LIGHT VALLEY SOLAR DEVELOPMENT CONSENT ORDER

Planning Inspectorate reference EN0110012

Deadline 3 Submission of Mrs Annette Exley

6 October 2026

P01

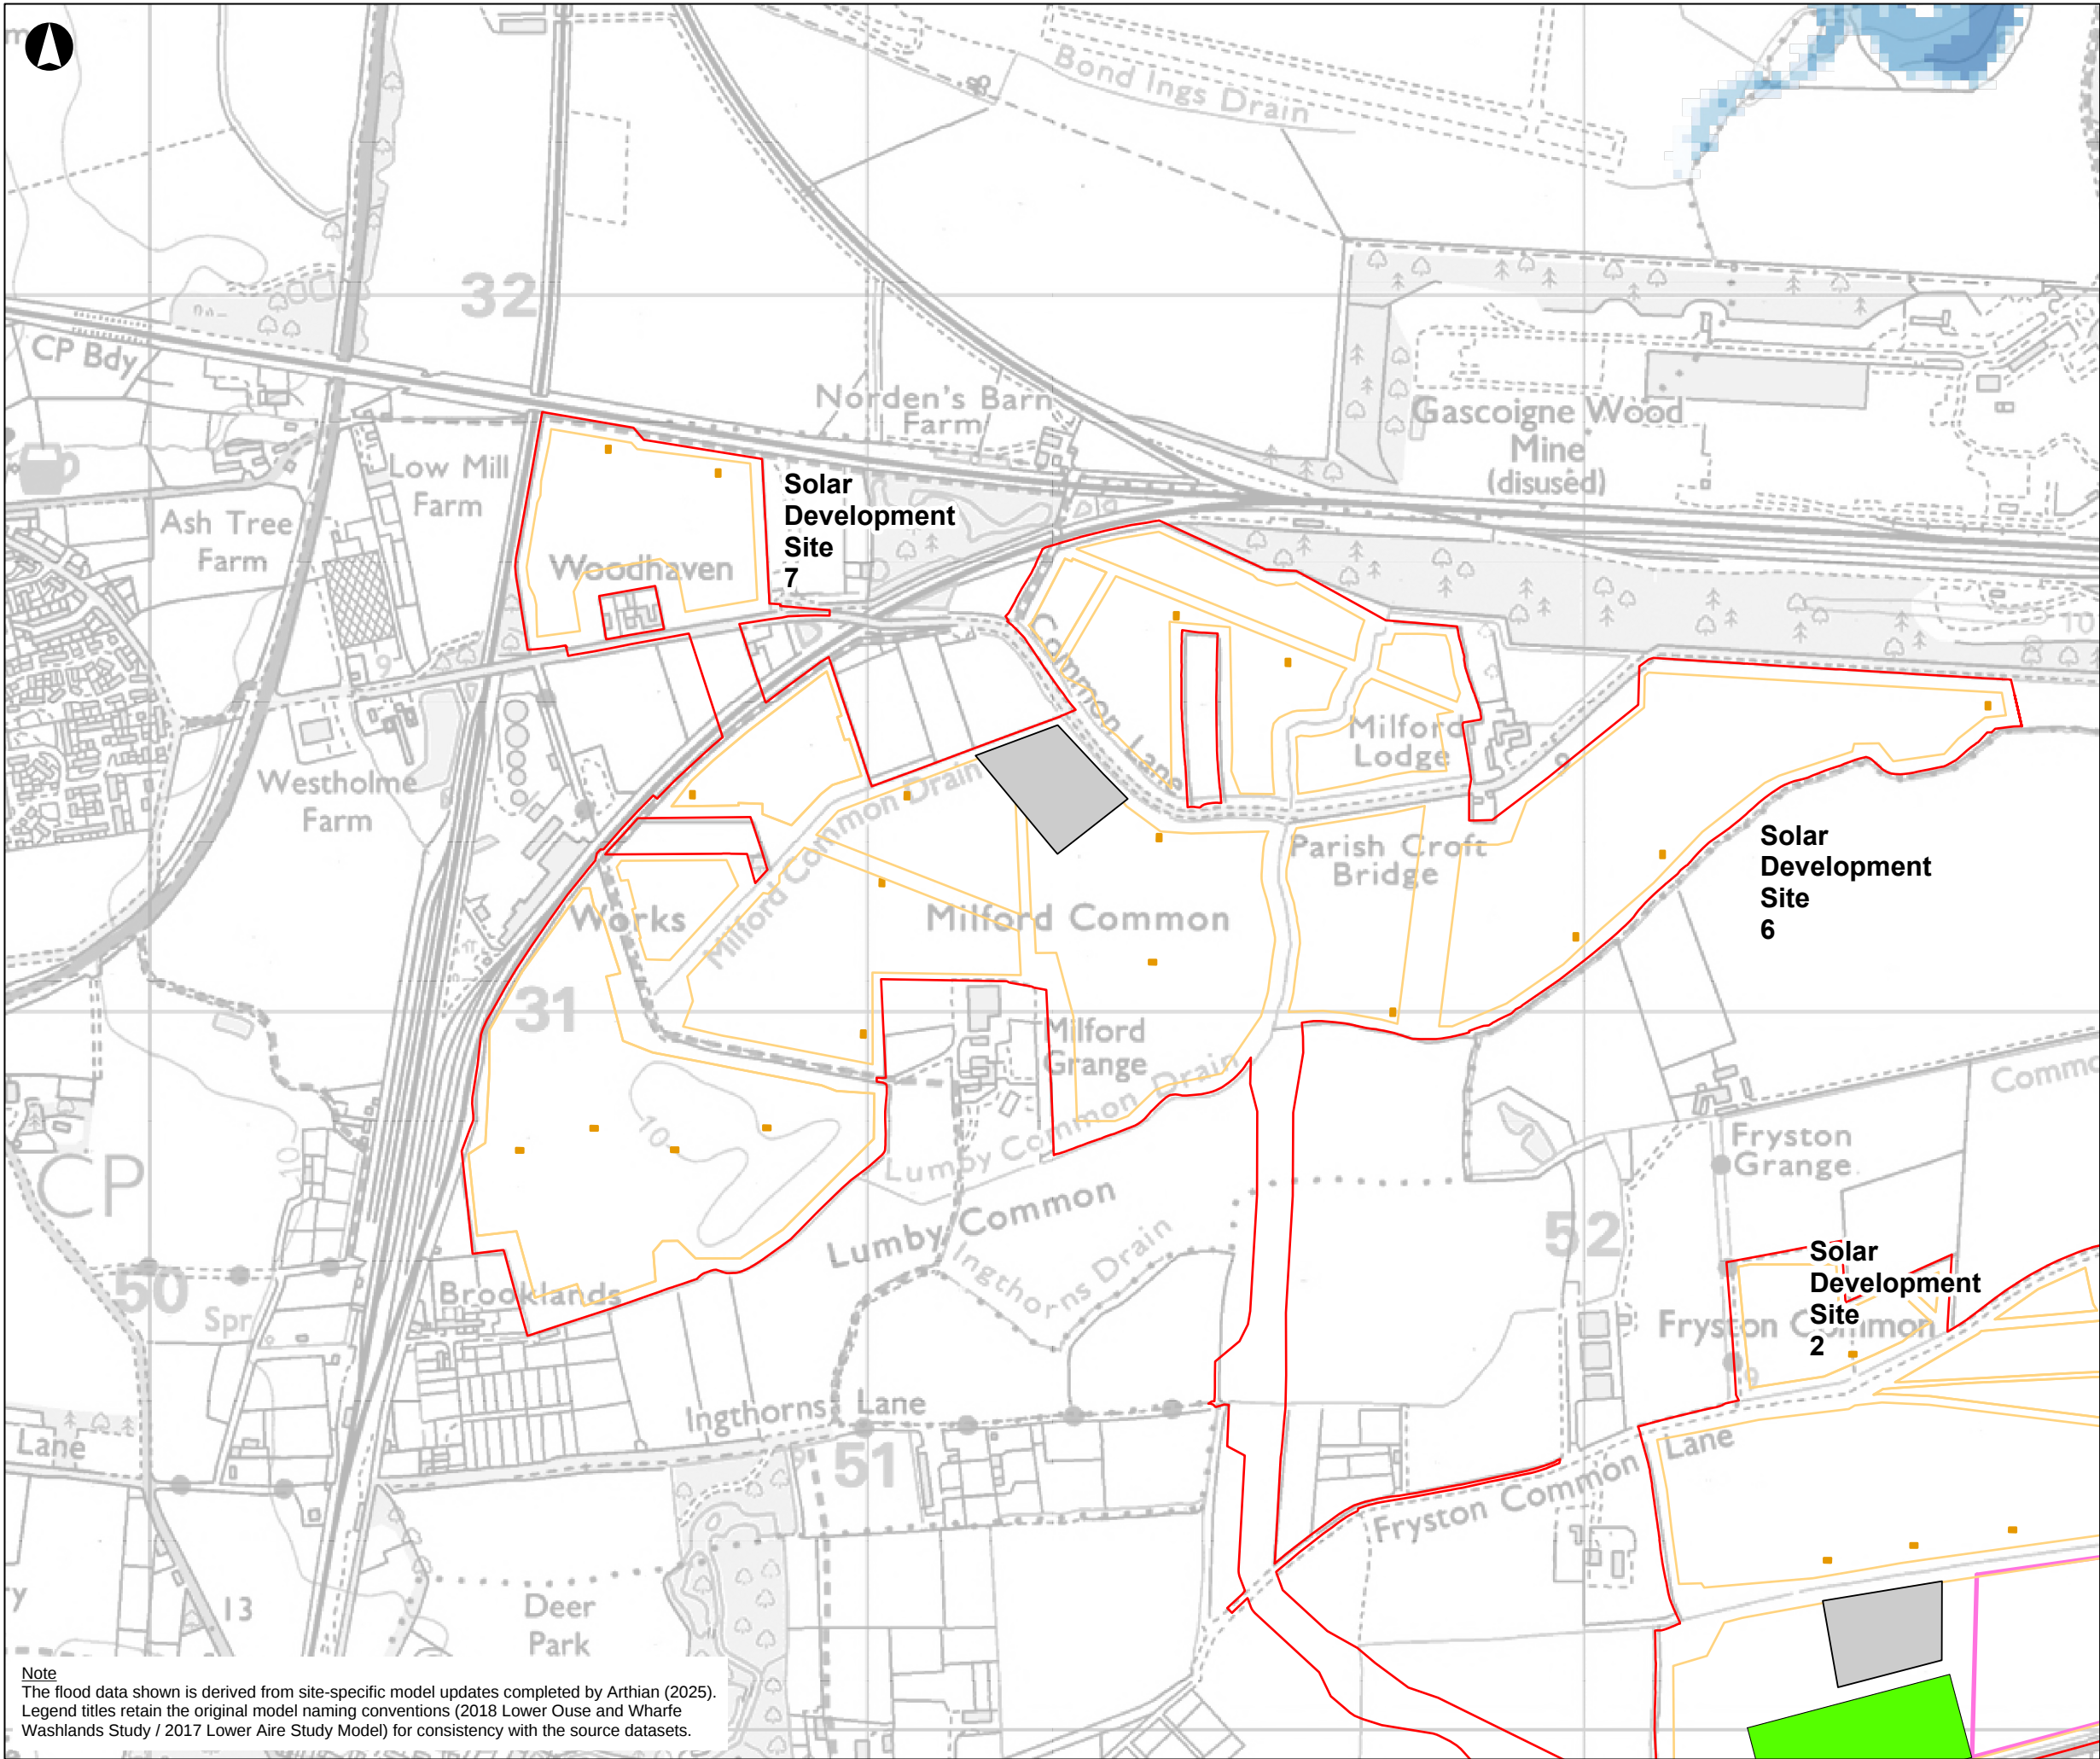
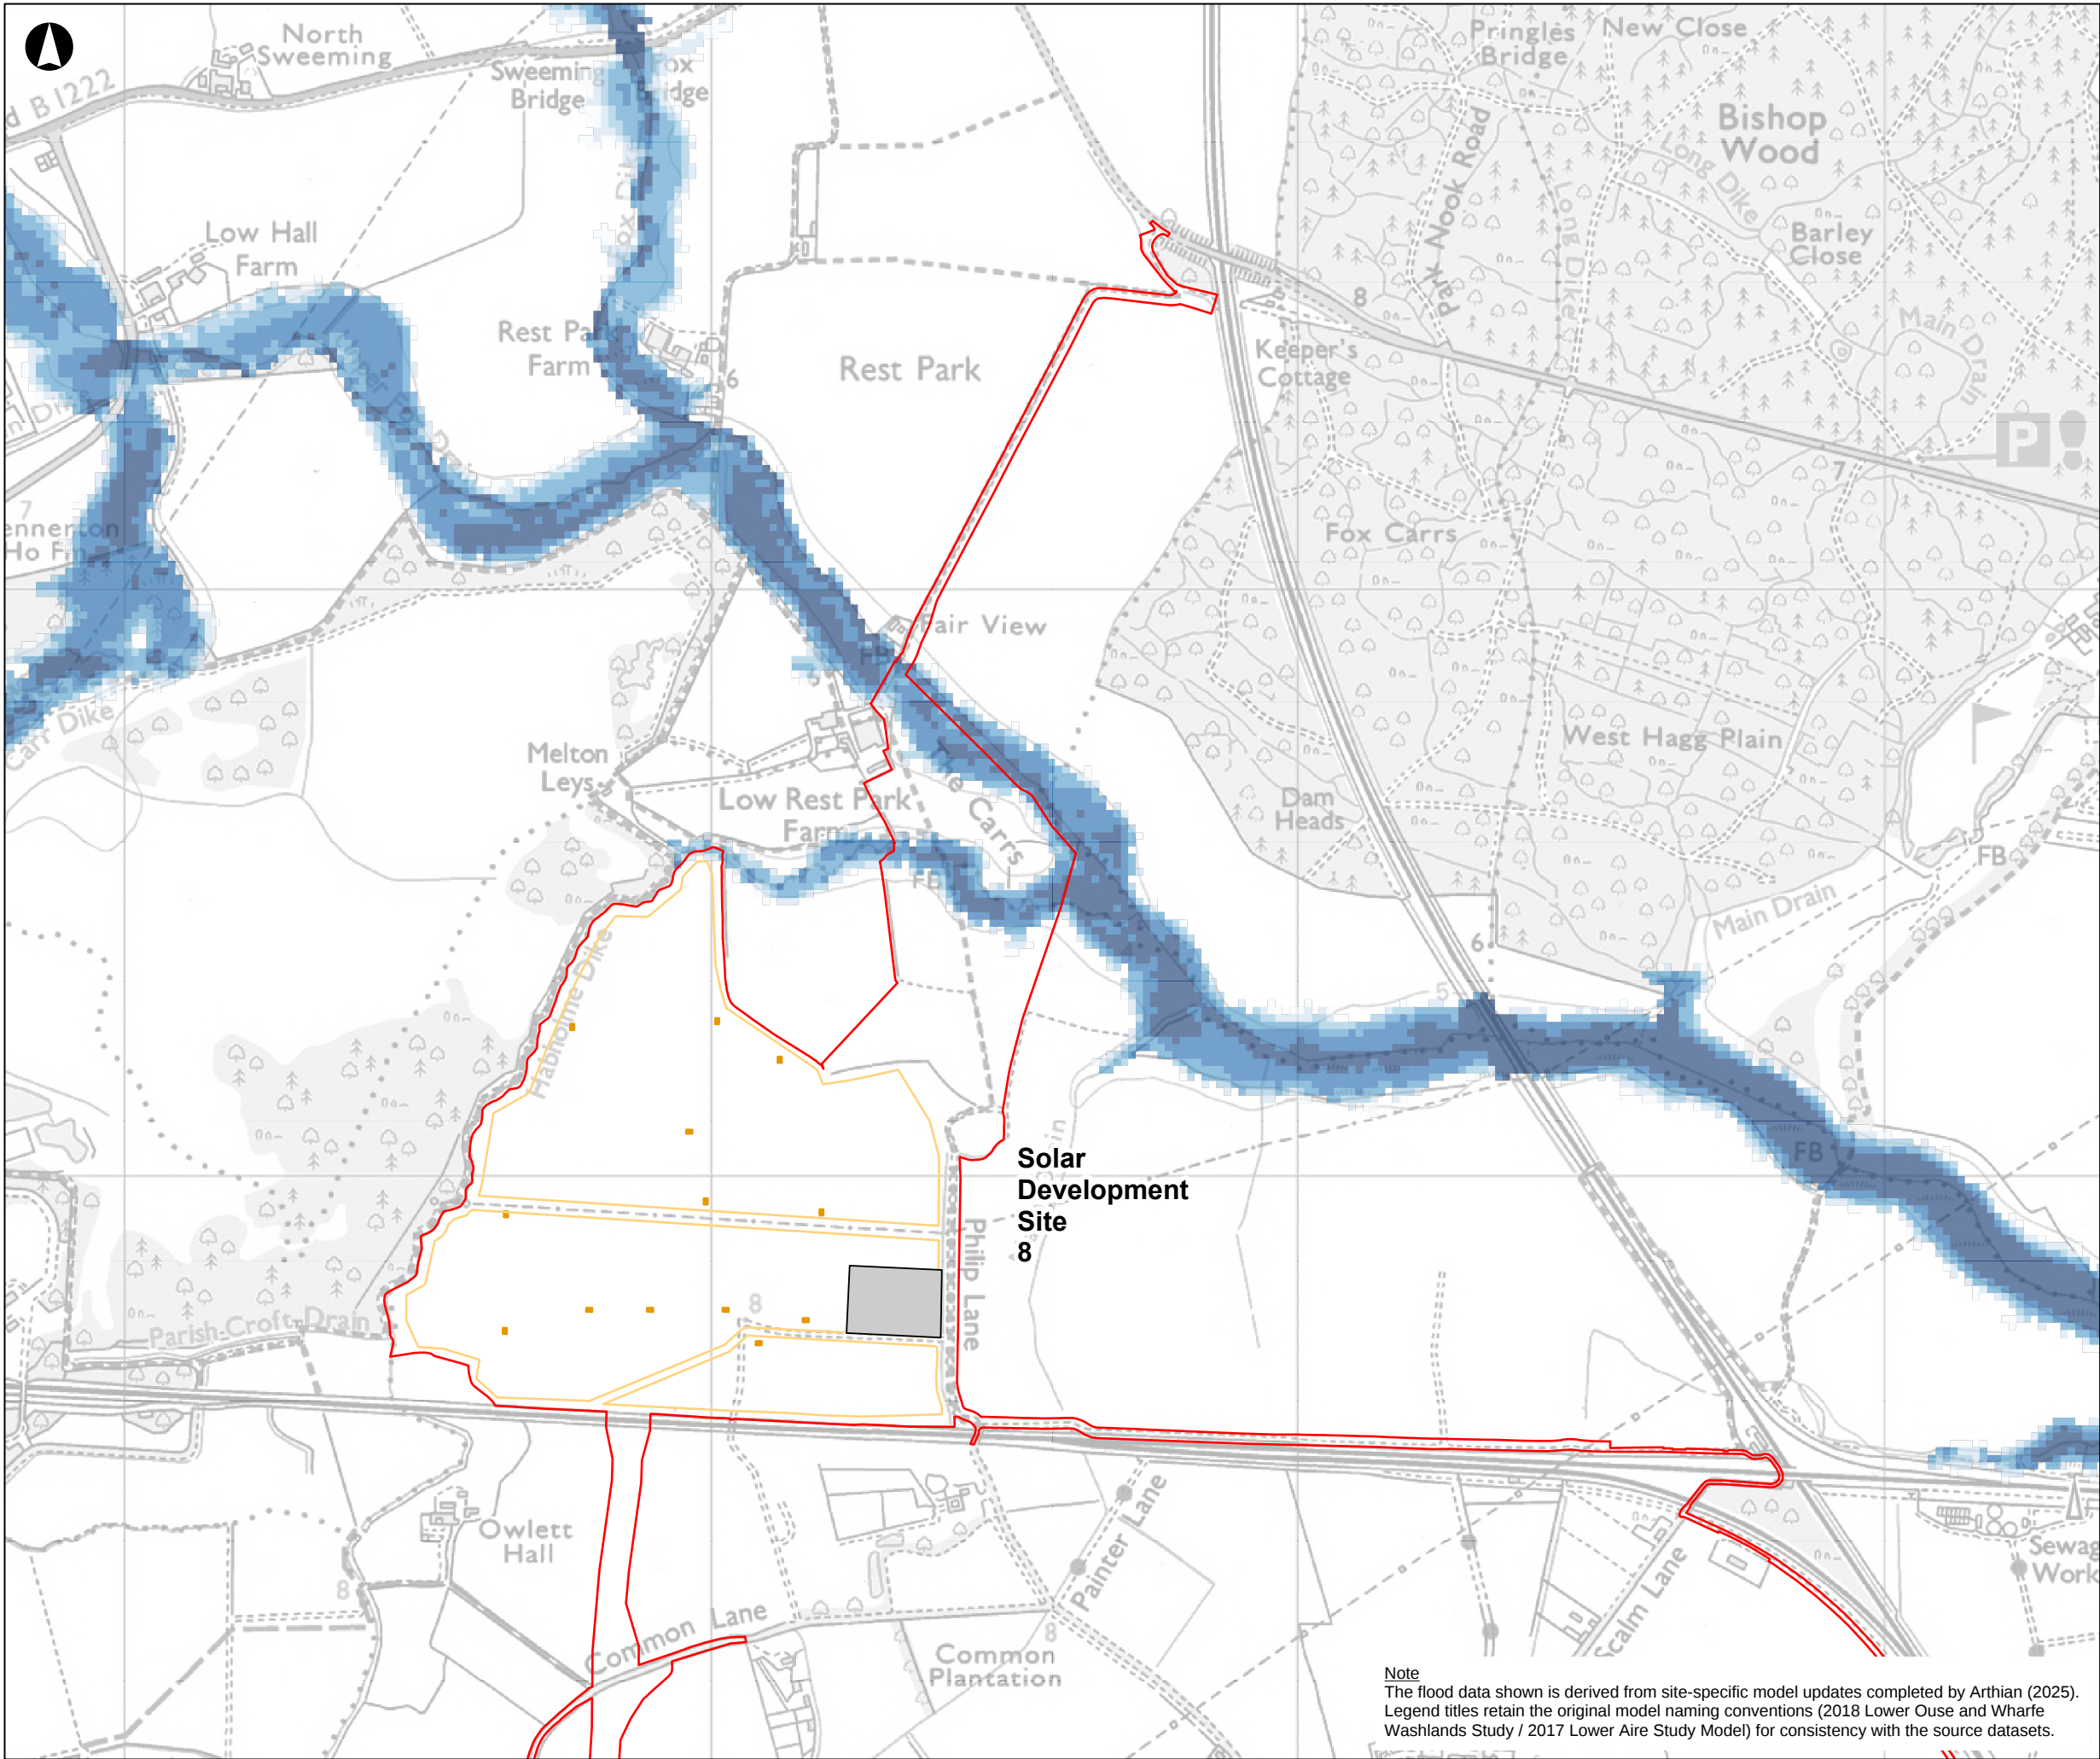
A.18 **[DF]** The anticipated maximum flood depth above ground level at the Solar Development Site 1 conversion units in the **design event** is **+0.5 m**. That figure appears nowhere in ES Volume 1 Chapter 15 [REP2-043], nowhere in Figure 15.27 [AS-041], and nowhere in the Applicant's response at [AS-040].

A.19 **[DF]** Paragraph 8.1.9 of the Flood Risk Assessment states that panels within the design flood extent at Site 1 "will be raised above the modelled design flood level in the corresponding location in accordance with the applicable freeboard parameters or, **where this is not practical**, panel layouts will be refined to avoid flood-affected areas". The same qualification appears on sheet 1 of Figure 15.27. I invite the Examining Authority to consider what secures either limb of that alternative.

B.2.1 **[DF]** The Examination Library records Chapter 15 figures as APP-115 (Figure 15.1) through APP-140 (Figure 15.26), each with an application-stage entry dated 10 February 2026. **There is no application-stage entry for Figure 15.27 or Figure 15.28.** They appear only as AS-041 and AS-042, additional submissions accepted at the discretion of the Examining Authority.

B.2.4 **[DF]** The drawings are stamped revision **P01** — first issue — dated 09/09/2026. The Guide to the Application [AS-038] logs both as "Version 2.0". There is no Version 1.0 of either.

B.2.6 I invite the Examining Authority to require the Applicant to state whether Figures 15.27 and 15.28 form part of the Environmental Statement; if they are to be certified, by what mechanism they are to enter Schedule 13; and why a first-issue drawing has been logged as a second version.

B.2.7 **[DF]** Figure 15.27 is published in six sheets, numbered "Sheet Number 1 of 7" to "Sheet Number 6 of 7". **Sheet 7 of 7 is not published.** The sheet-location index in the corner of all six published sheets shows seven panels. **[RI]** The six published sheets cover all seven solar development sites, which leaves the cable route corridor as the likely subject of the missing sheet — that is, the one location the Applicant now accepts is within functional floodplain. I do not know what sheet 7 shows. I invite the Examining Authority to require its production and to require the Applicant to confirm what it covers.
